PORTLAND MAINE

August 22, 2008

RE: 46 Brook Road – 375 C012 – R-3 – pool application – Permit #08-1022

COMPANY 46 Brook Road
 PROJECT NAME Lot Layout
 DRAWN BY Larry Robinson DATE 03AUG08 1/32"=1'
 CONTRACT 1 SHEET DWG. REV.
 Number 1 NO. of NO. NO.

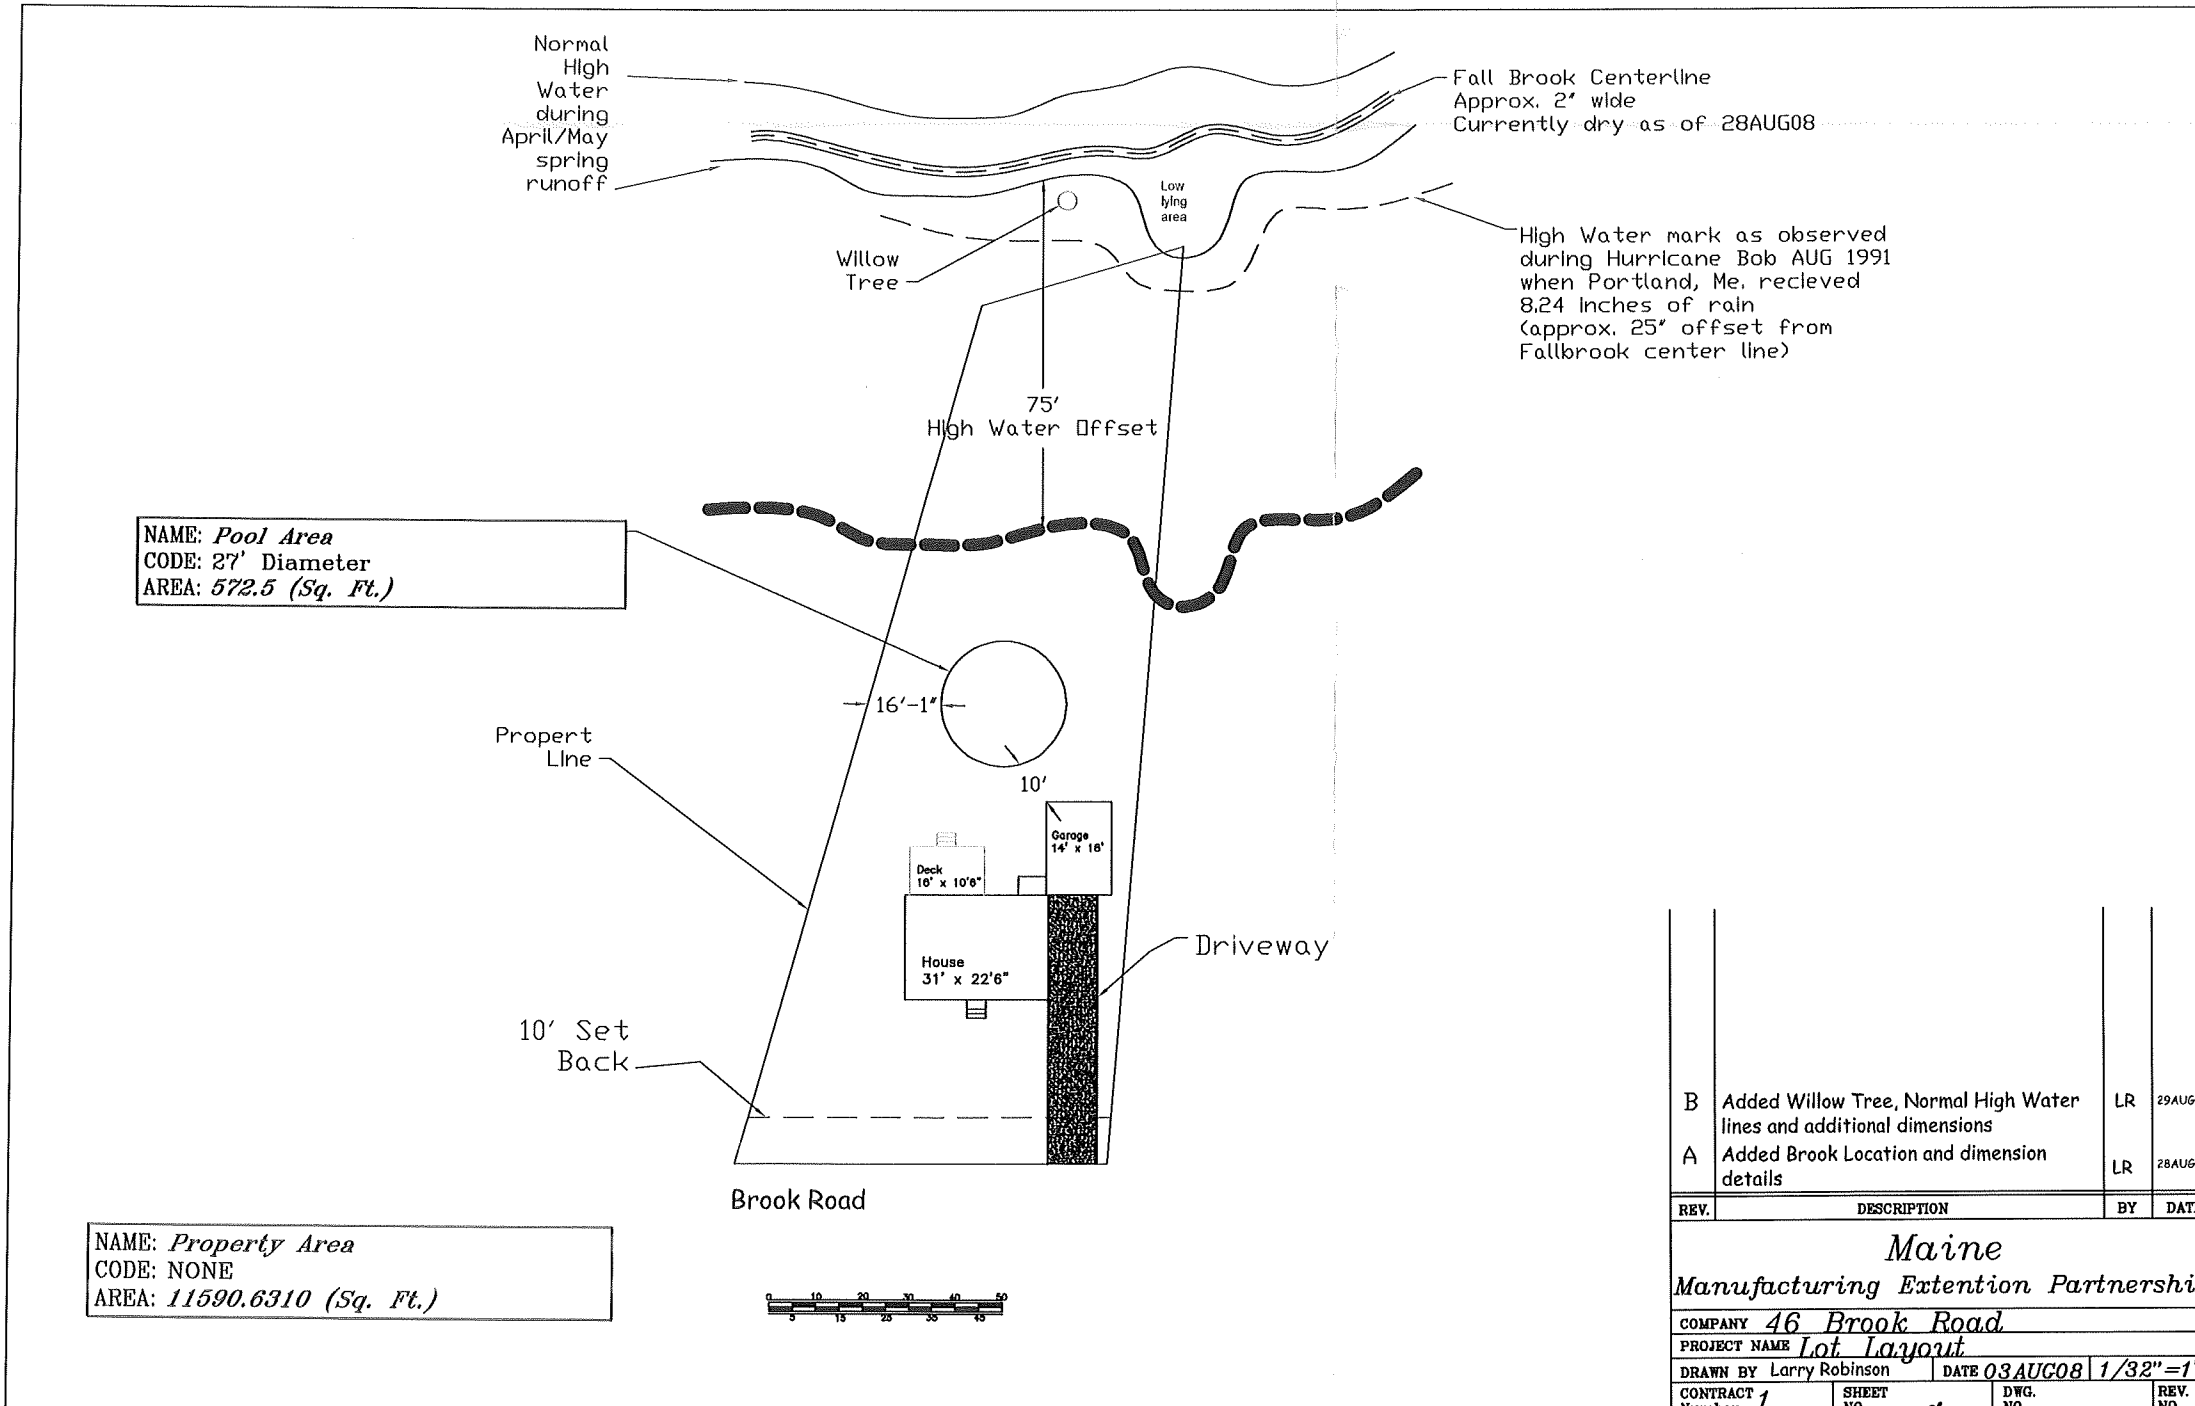
Part of your property is located within a Stream Protection Zone. Section 14-453 of the ordinance states that within the Stream Protection Zone a structure needs to be located a minimum of seventy-five feet from the normal high water line of the stream. It appears from the information provided that the proposed location of your pool might fall within this seventy-five foot setback. We need a site plan stamped by a professional that locates the seventy-five foot setback from the normal high water mark of the stream. The site plan must also show the location of the proposed pool and the existing structures on the property. This is necessary to determine that the pool is not located in the seventy-five foot setback.
